<b>Consultation Response from: KC Environmental Health (Pollution &amp; Noise Control)</b>		
<b>2021/93644 - Low Farm, Wakefield Road, Flockton, Huddersfield, WF4 4BB</b>		
<b>Erection and operation of grid-connected solar photovoltaic farm, with ancillary infrastructure and landscaping and biodiversity enhancements</b>		
<b>Responding Date:</b> <b>25<sup>th</sup> January 2022</b>	<b>Responding Officers:</b> <b>Mohammed Nasim – Noise</b> <b>Natalie Heaney – Contaminated Land</b>	<b>Responding Ref:</b> <b>WK/202133603</b>
<p>The application seeks full planning permission for the installation of a renewable energy generating station consisting of ground – mounted photovoltaic solar panels, transformer stations, site accesses and access gates, security measures and other ancillary infrastructure. The site is located within the Parish of Kirkburton, between Overton (about 700 m east-northeast) and Grange Moor (approximately 700 m east-northeast). The site consists of eight parcels of land (plus an additional parcel necessary for the link to the national grid), three to the south and six to the north of Wakefield Road (approximately 800 m to the west). Flockton is about 75 metres to the

Drawing Information	
Scale	1:5000 @ A0
Stage	ISSUED FOR REVIEW
Drawing Name	Overall Layout
Drawing Number	B001
Designed By	Samuel Hogan
Sheet 1 of 1

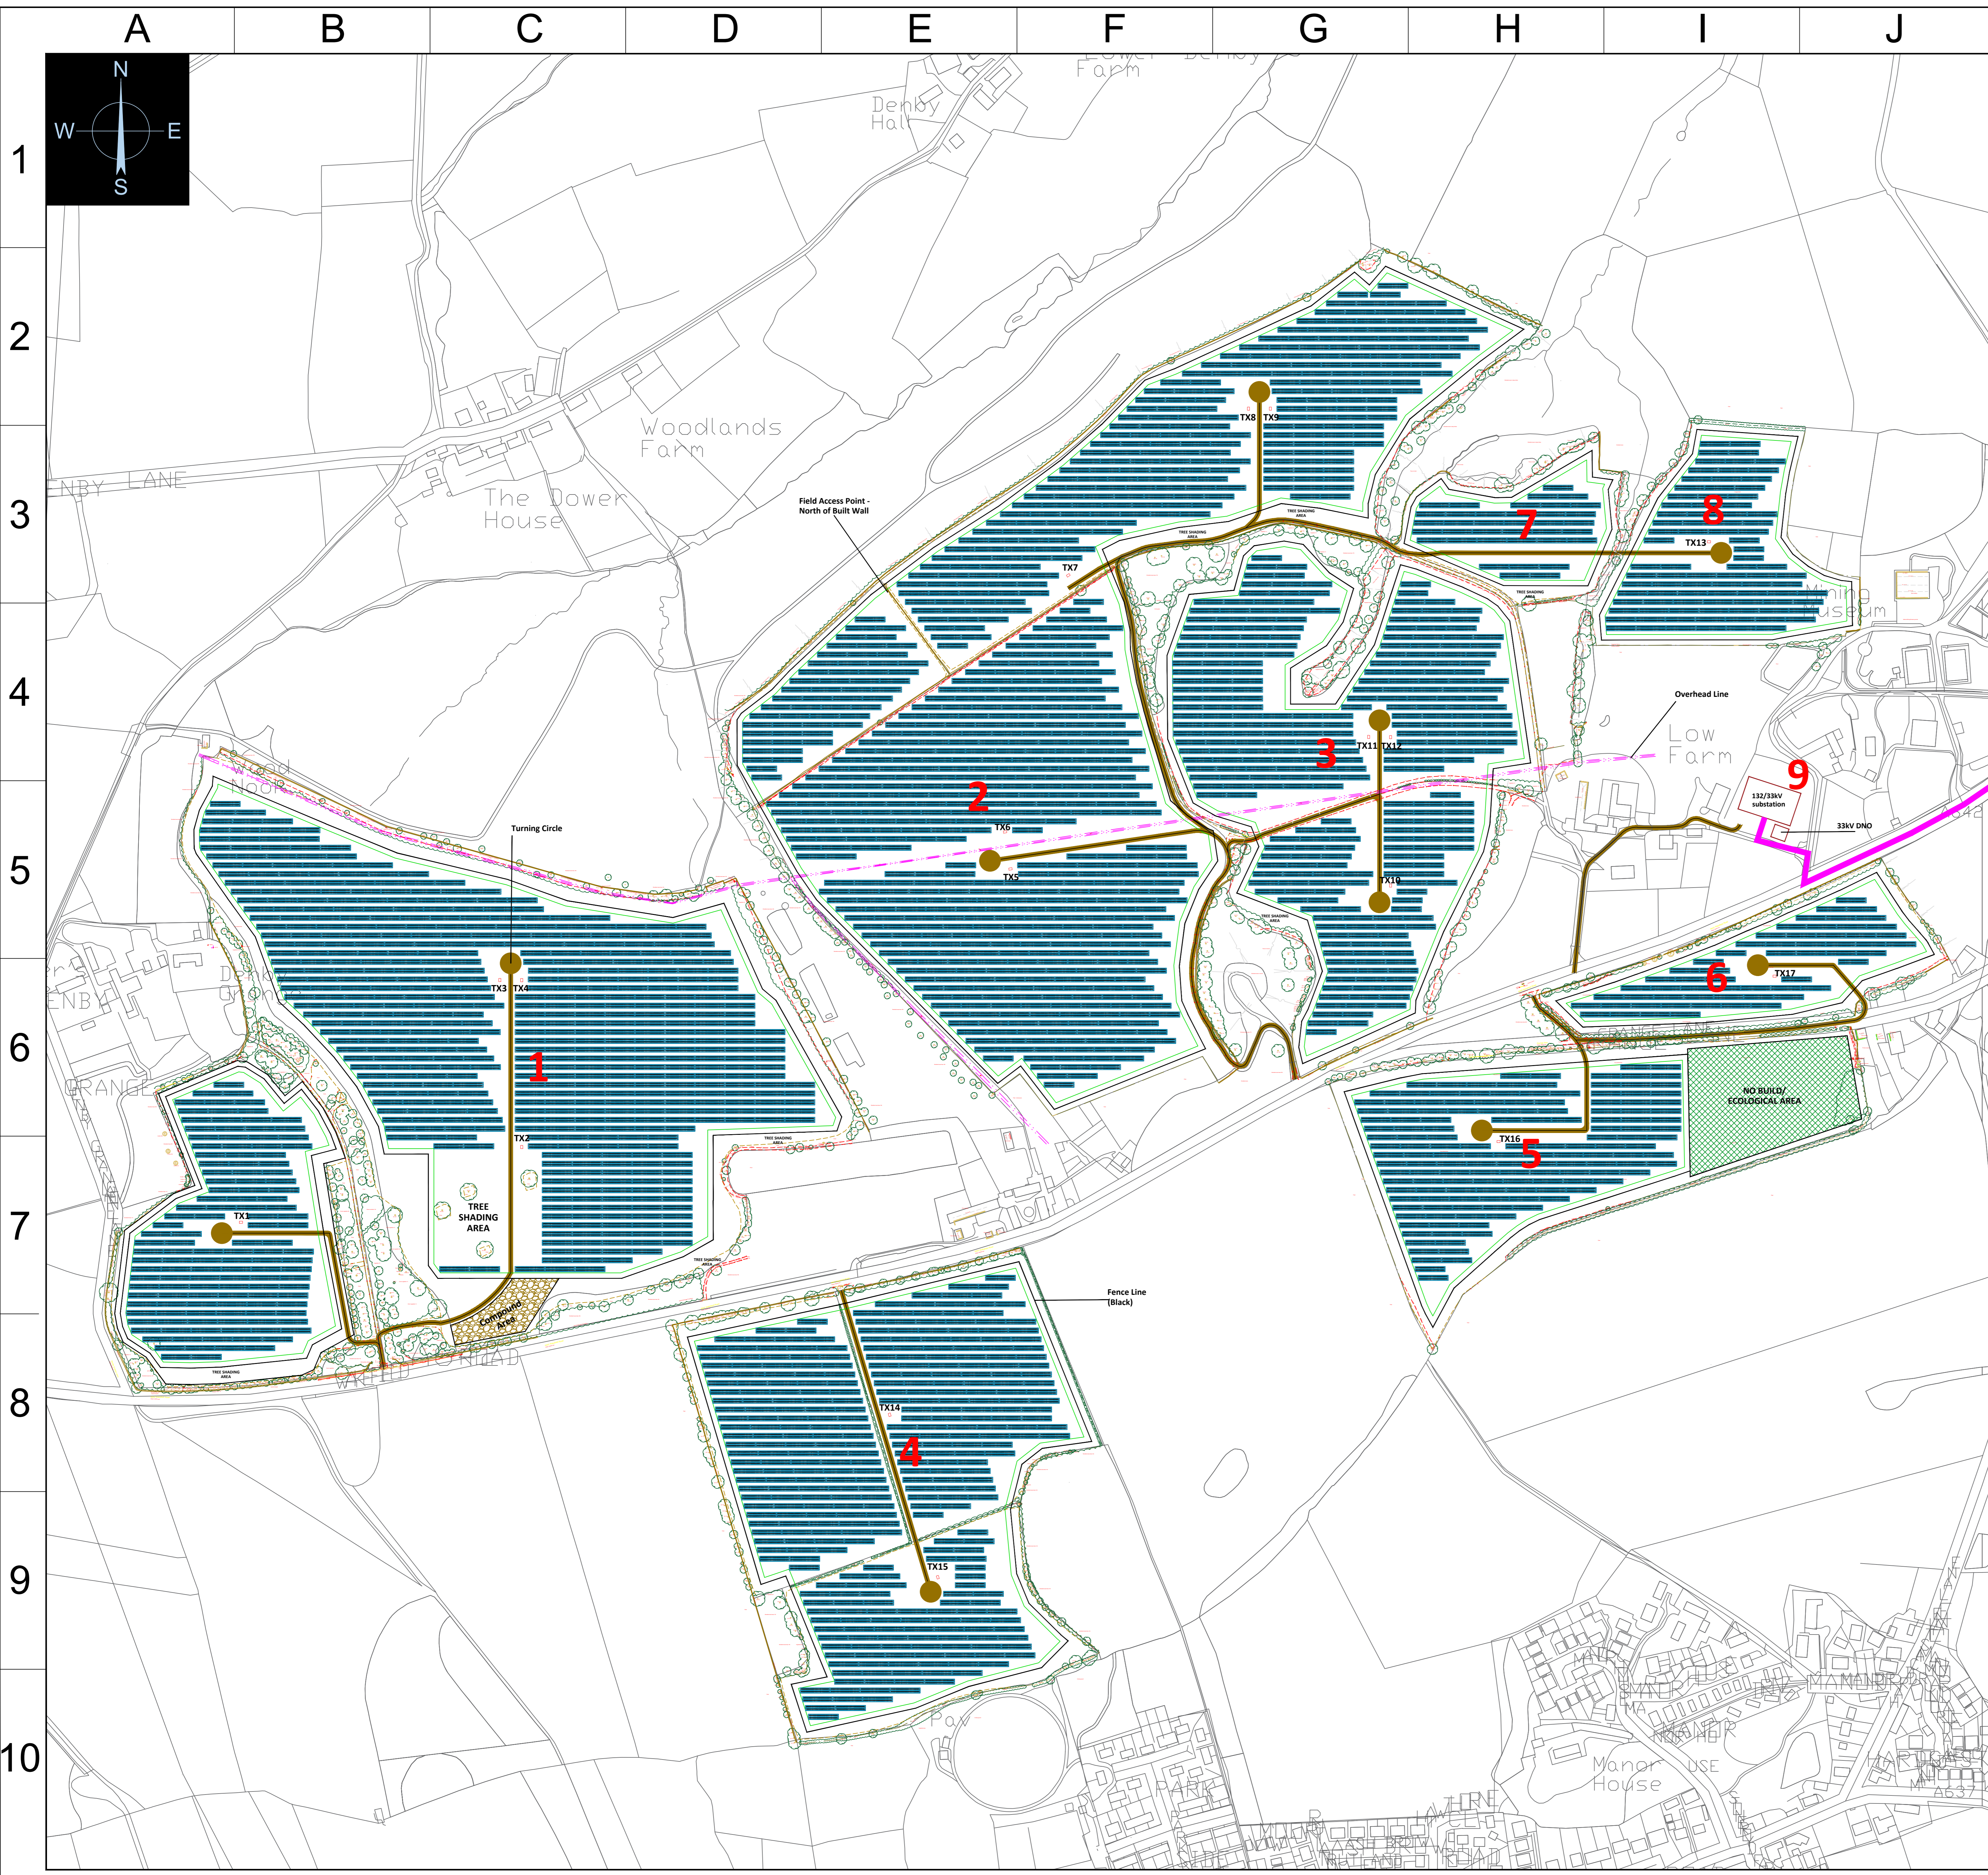
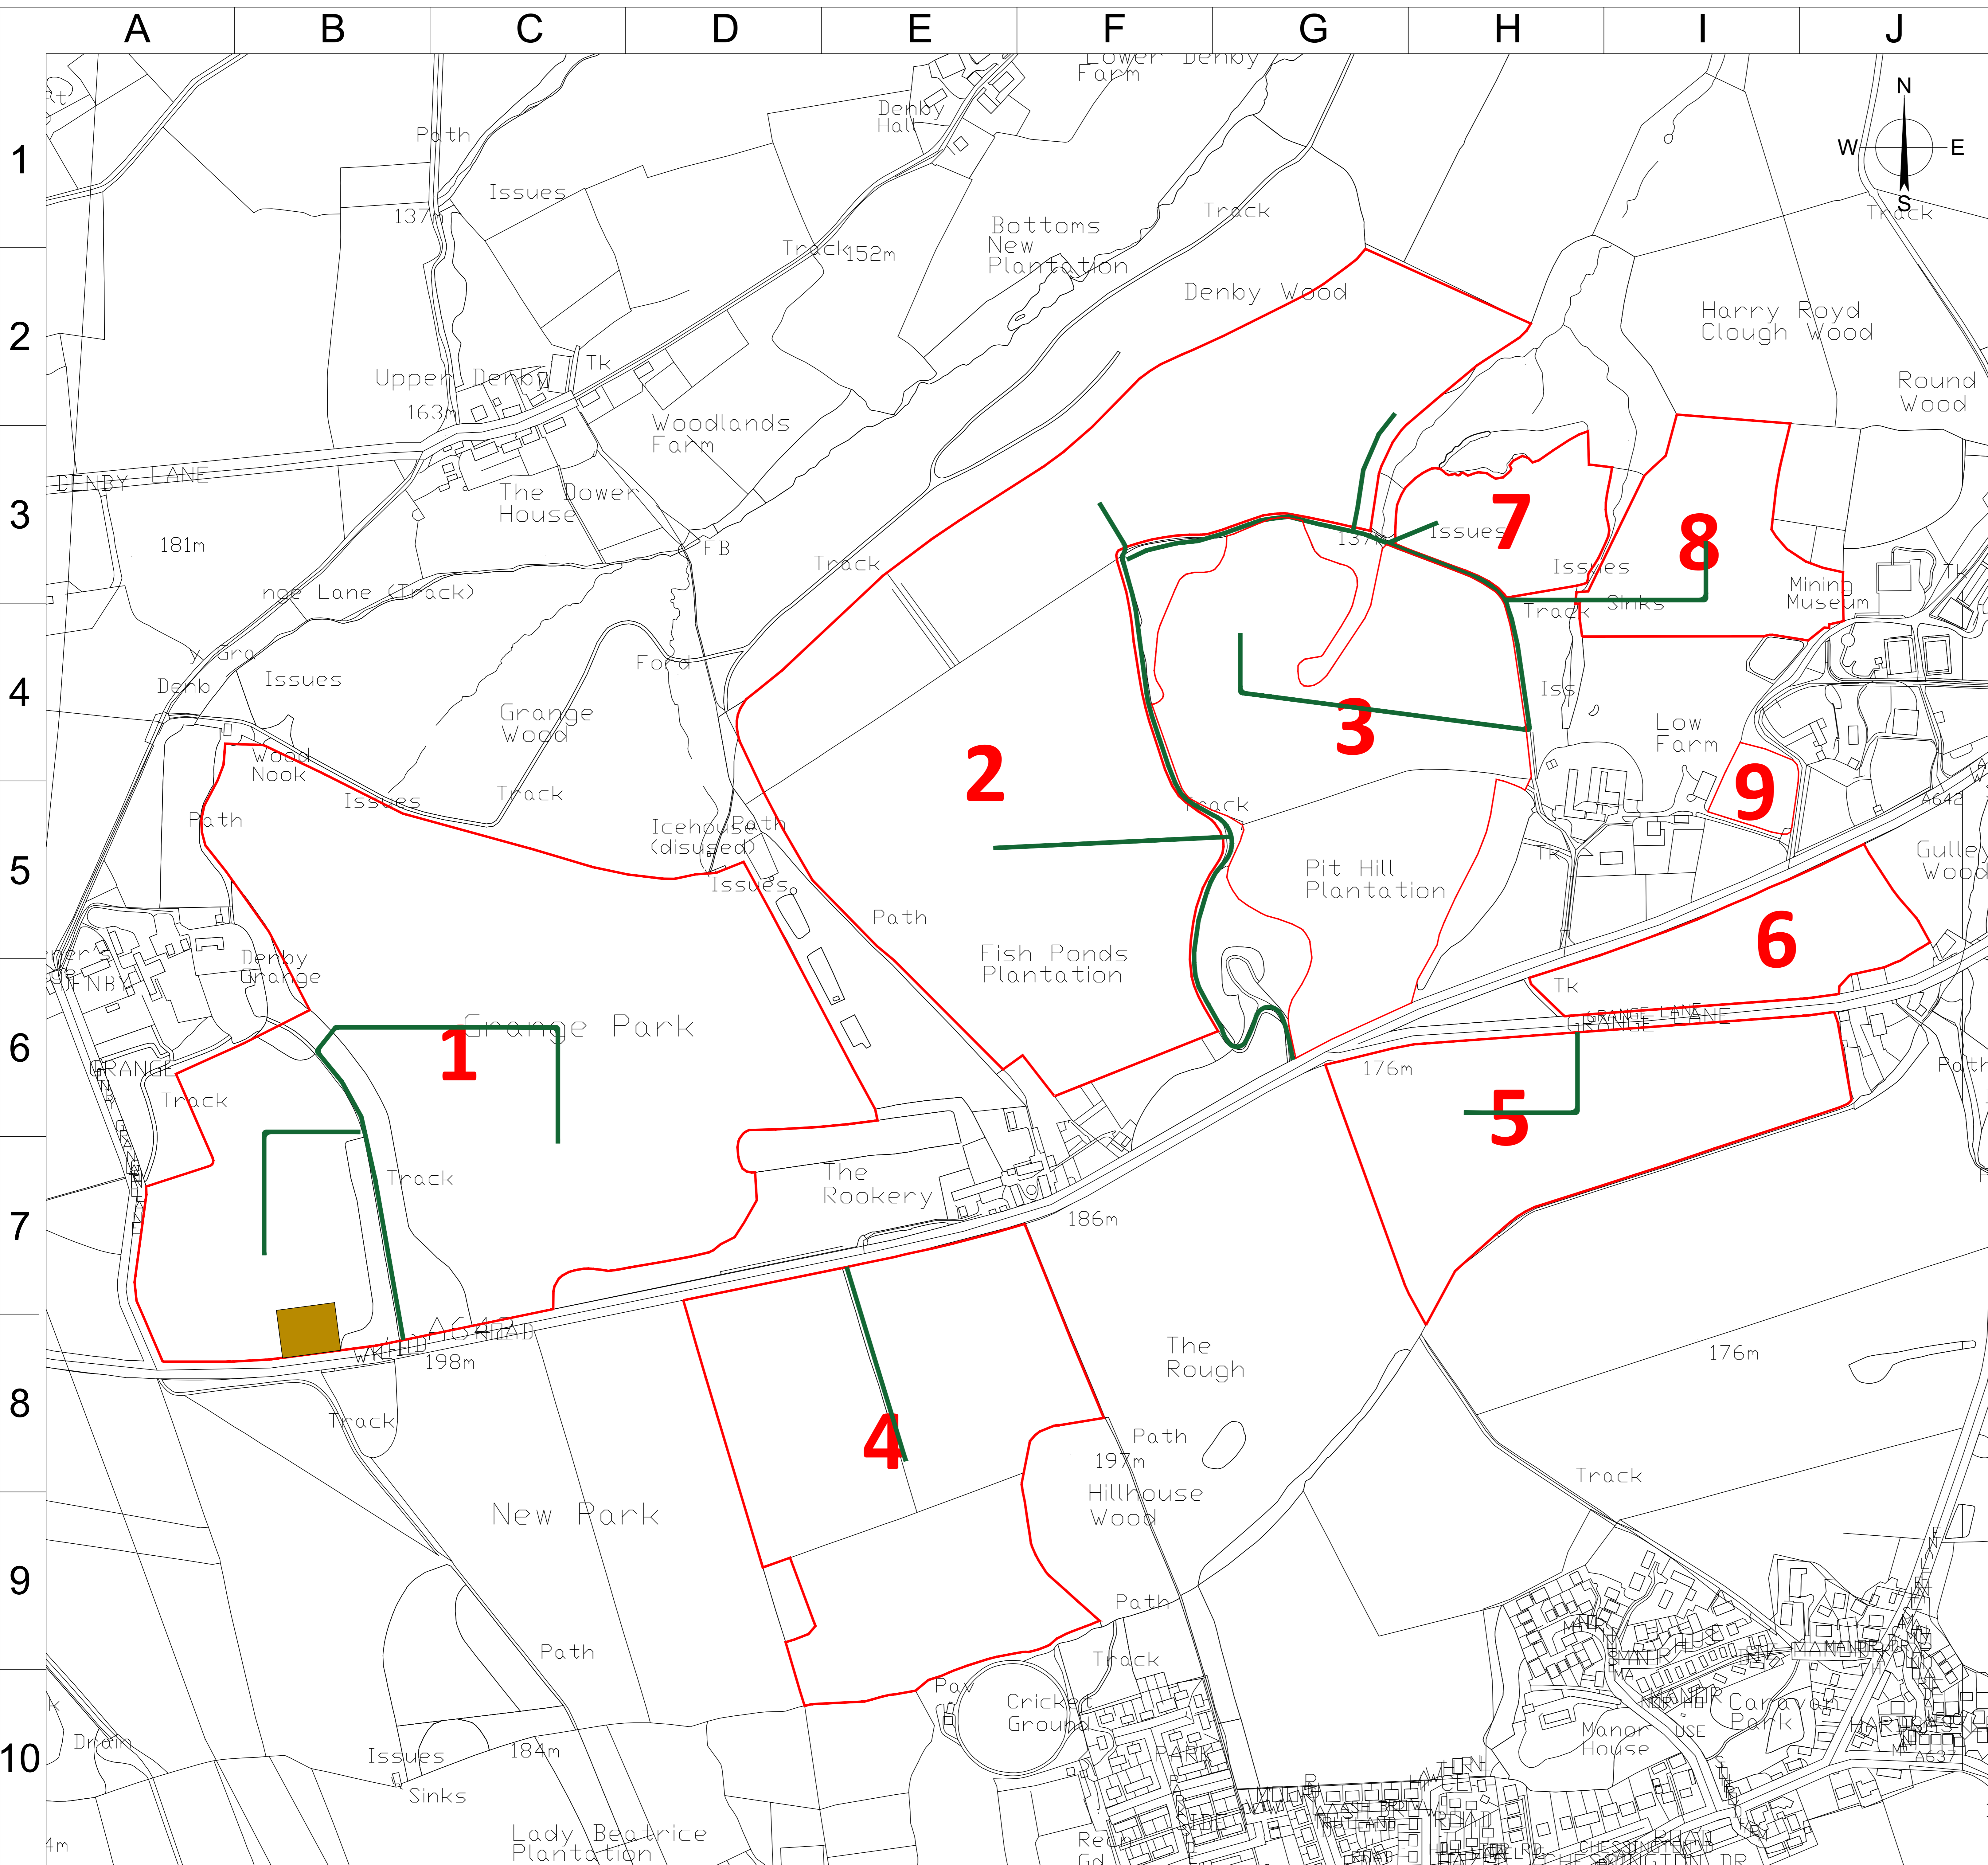
Drawing Number B001 v3.3 from Boom Power shows both substations are located at Low Farm and consideration must be given to any noise emissions, particularly at low frequencies, from these substations which may affect the amenity of the occupiers in this area. This will need to be addressed through an addendum to the submitted NIA before further comment is made on the suitability of the proposal. A condition is recommended.

**Recommended Conditions****NC8 Noise Report required for proposed noise generating use close to existing noise sensitive premises - Condition**

Before construction work commences, a further noise assessment report by a suitably competent person shall be submitted to and approved in writing by the Local Planning Authority. The report shall include –

- a) an assessment of all of the noise emissions from the proposed development
- b) details of existing background and predicted future noise levels at the boundary of the nearest noise sensitive premises
- c) a written scheme of how the occupants of the above-mentioned noise sensitive premises will be protected from noise from the proposed development including details of all necessary noise attenuation
